Ecological comments

Application: 3/2012/00797

Proposals: Proposed Static Caravan/Lodge Park

Location: Land at Southport House Sawley Lancashire BB7 4ND

Map 1 Extended Phase 1 Habitat Survey

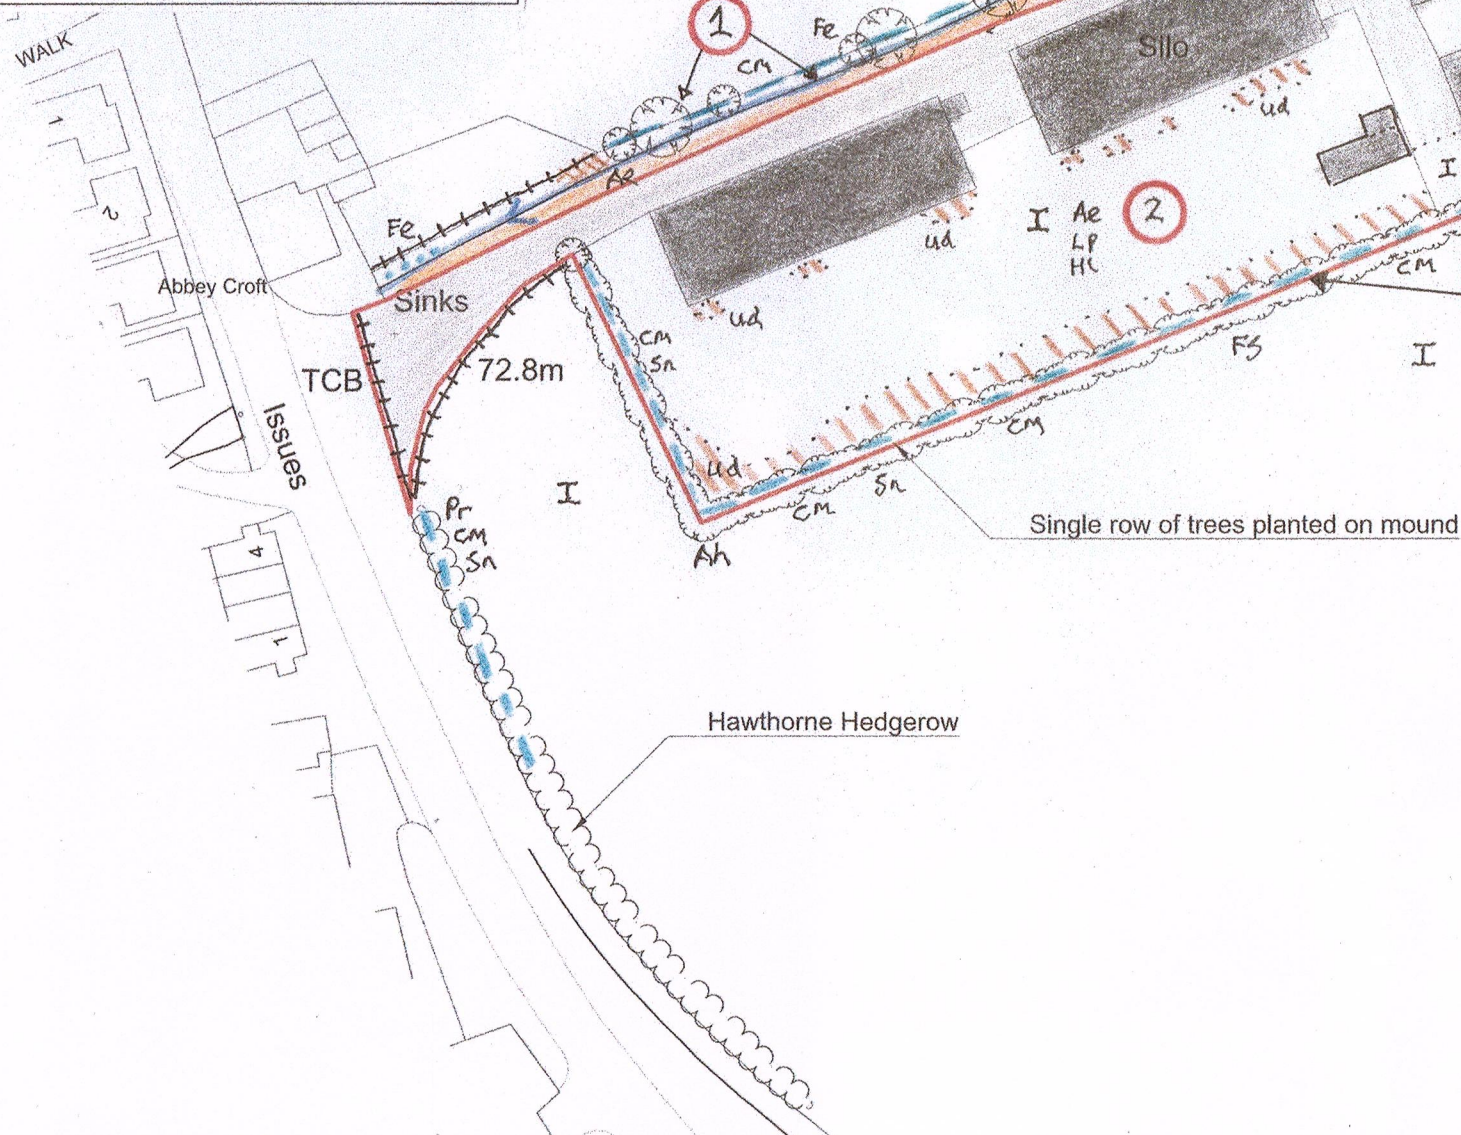
The application area appears to be of relatively low biodiversity value, and significant impacts on protected or priority species or habitat therefore seem reasonably unlikely.

The proposals offer the opportunity to enhance site boundaries, and I note the plans indicate that trees would be planted. It should be ensured that all hedgerow and tree planting comprises native species appropriate to the local area only.
